DRB Application No.: 05DRB-01709 (SPS)  
Project Name: QUARTERS PLAZA OFFICE BLDG.  
Agent: Martin Grummer

**DRB CASE NO/PROJECT NO: 1001623**

Date: 15 November 2005  
To: Sheran Matson, DRB Chair  
From: Russell Brito, Senior Planner  
RE: Project # 1001623: 05DRB-01709 / 01710 / 01708

DRB-1001623      Item No. 9      Zone Atlas A-14

TYPICAL AISLE ISLAND

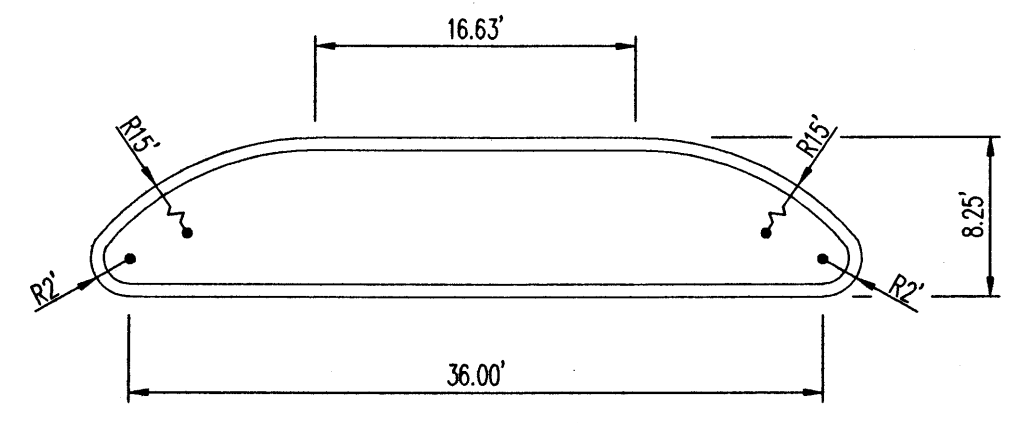
- A minimum radius of 15 feet is needed on all aisle islands.
- Label all wheelchair ramps either unidirectional or multidirectional ramp.
- Make sure all radii's are labeled and dimensioned.
